**From:** Teske, Mark S (DFW) <Mark.Teske@dfw.wa.gov>  
**Sent:** Friday, January 04, 2013 5:19 PM  
**To:** Jeff Watson; Dan Valoff  
**Cc:** Renfrow, Brent D (DFW); Harvester, Perry J (DFW)  
**Subject:** RE: Kittitas County Notice of Application  
**Attachments:** Aerial-2009-Flood-Rosenberry\_P1090117-detail1.jpg; Aerial-2009-Flood-Rosenberry\_P1090117-MasonCr.jpg; Teanaway-Rosenberry4.jpg; Teanaway-Rosenberry5-3m-ditch.jpg

**Subject:** Kittitas County Notice of Application

[SP-12-00007 Downs](#)

DOWN'S SHORT PLAT

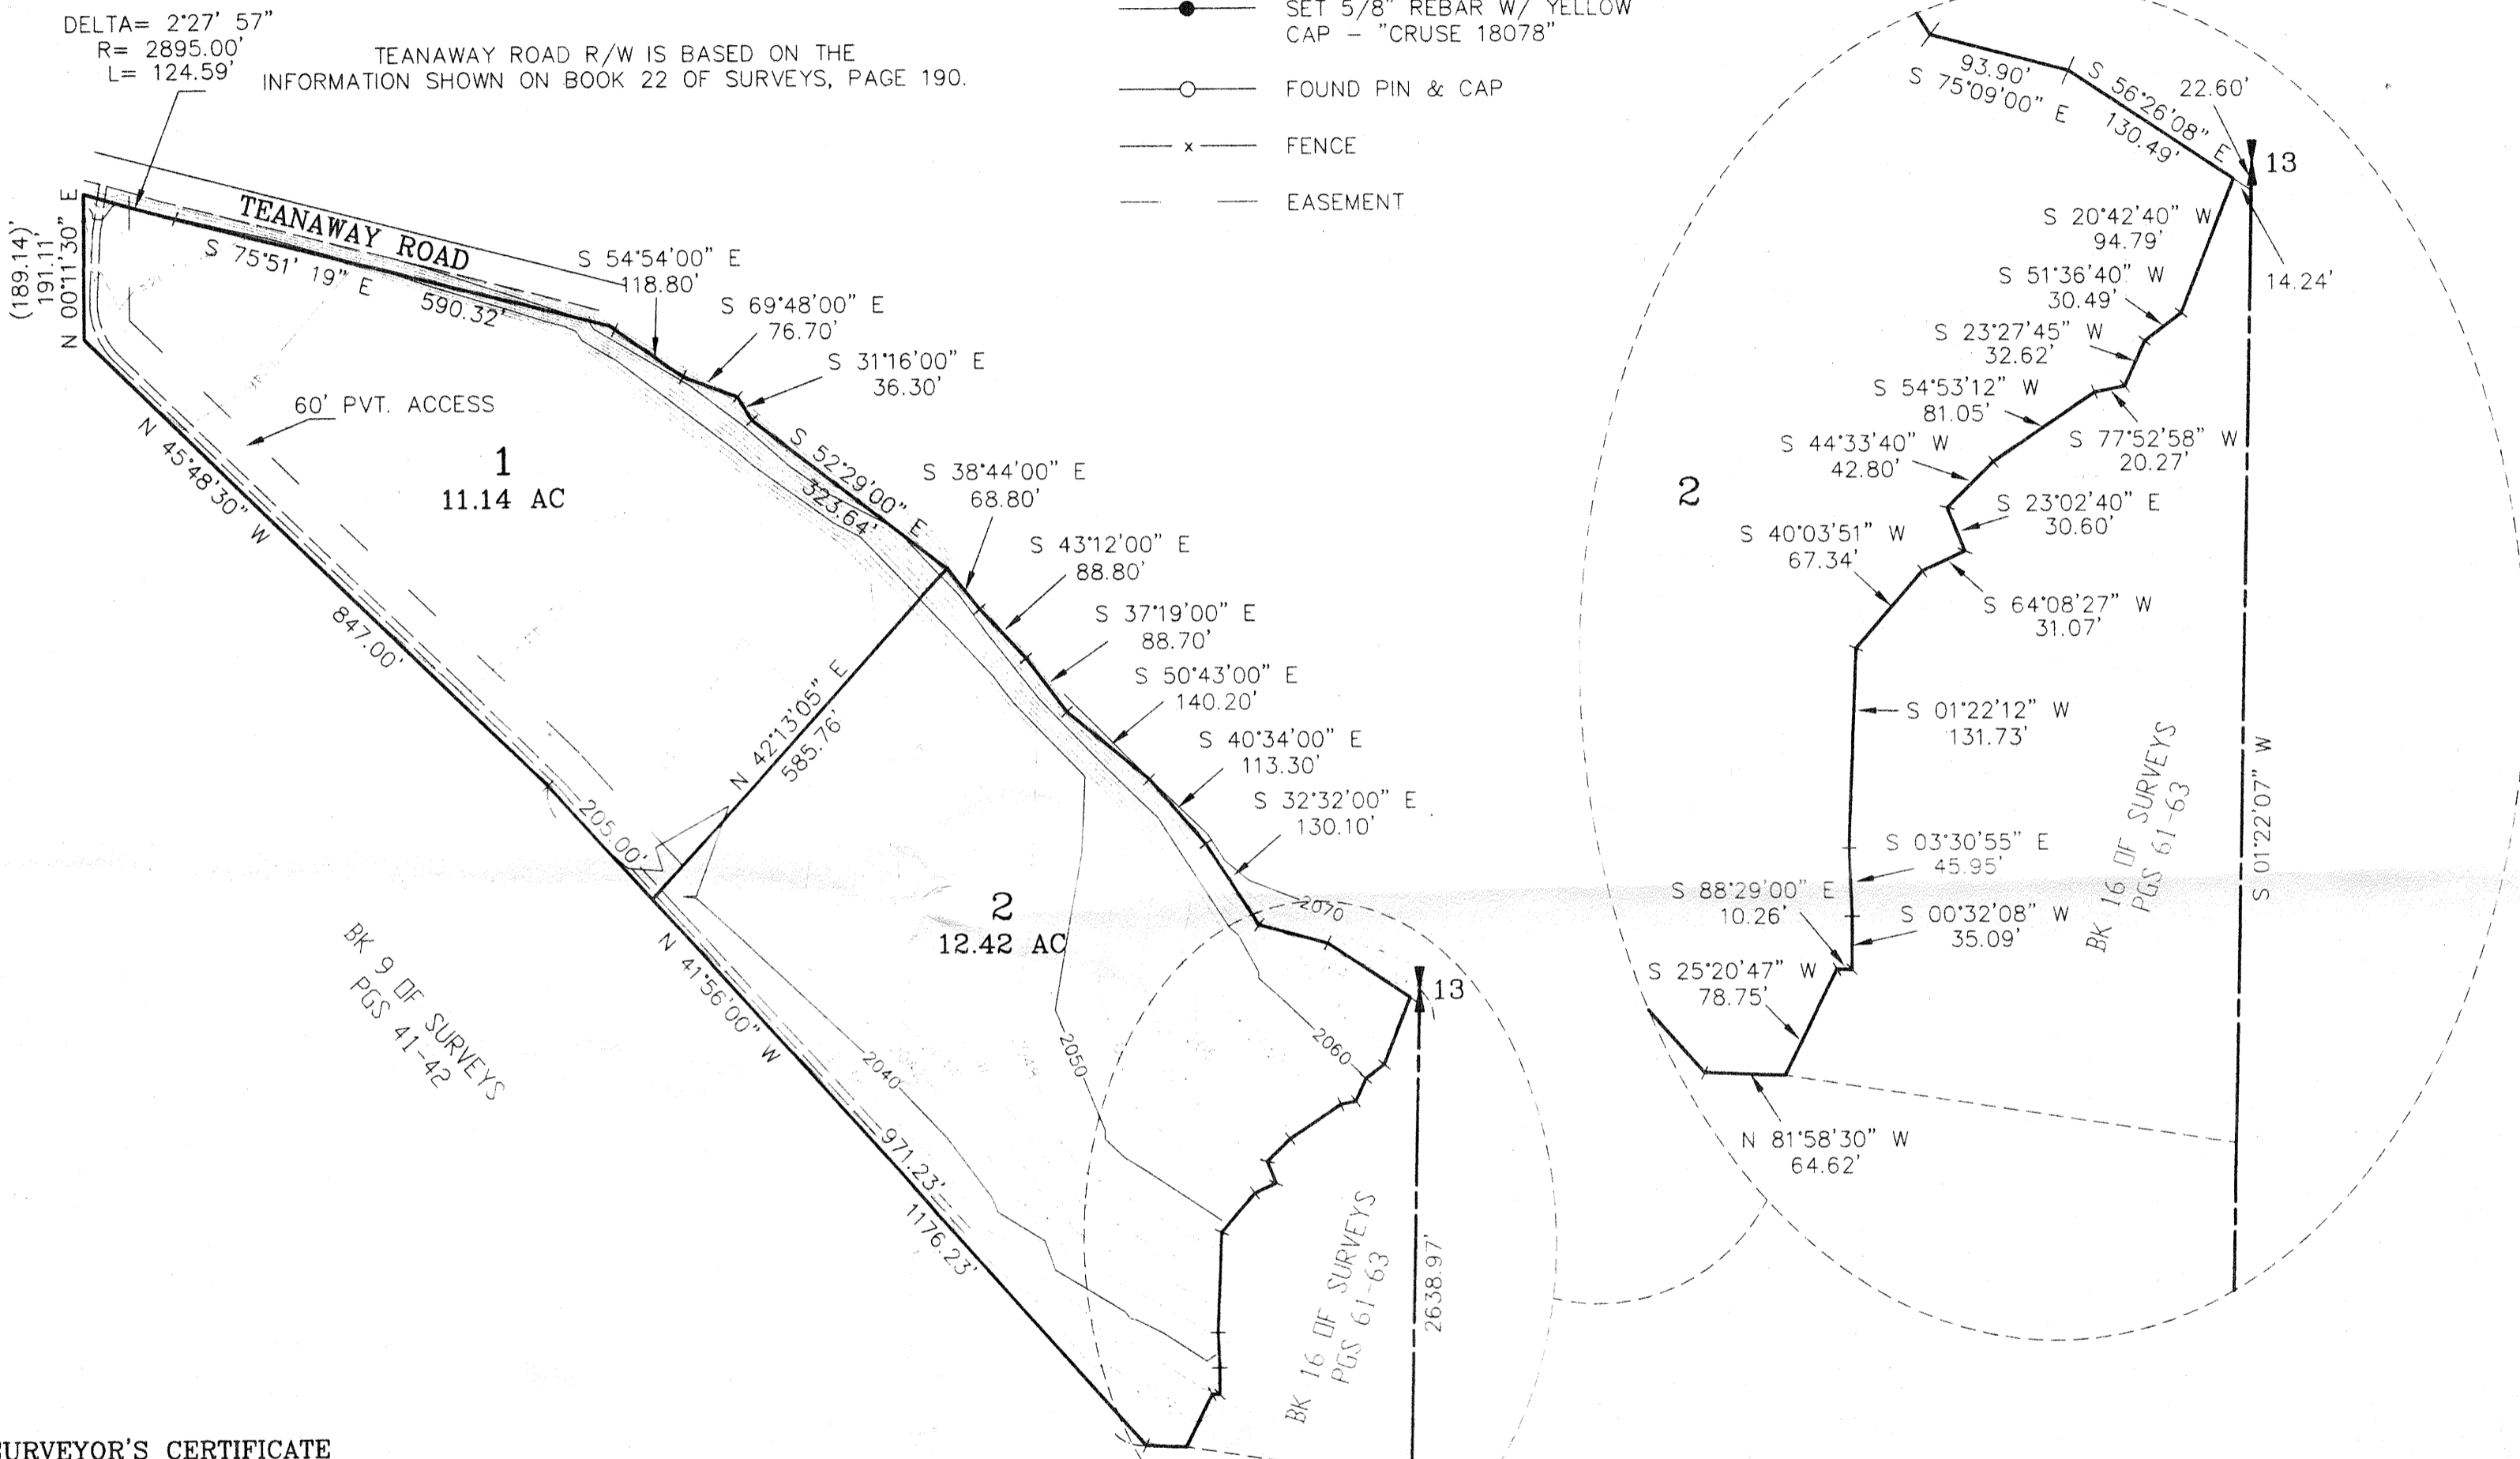
Attached are few photographs of the Teanaway River during a high water event in 2009. The FEMA floodplain delineation in the land use application material you provided appears to differ from the location where the river was in 2009. The property appears to have major drainage issues, with standing water evident on significant portions of one of the proposed parcels. Additionally, the "road" that exists between the property and the Teanaway River acts as a "dike" and artificially blocks the river from the floodplain. This impacts fish habitat of the listed and resident fish in the Teanaway River. This "road/dike" feature is likely not engineered to any accepted standard and reliance on it as protection from flooding is highly questionable. This section of the Teanaway River appears to be dynamic laterally when compared to upstream or downstream segments. It is a depositional area and is diverse and comparatively complex habitat within the reach. Mason Creek is an issue as well with development potentially impacting this fish bearing tributary.
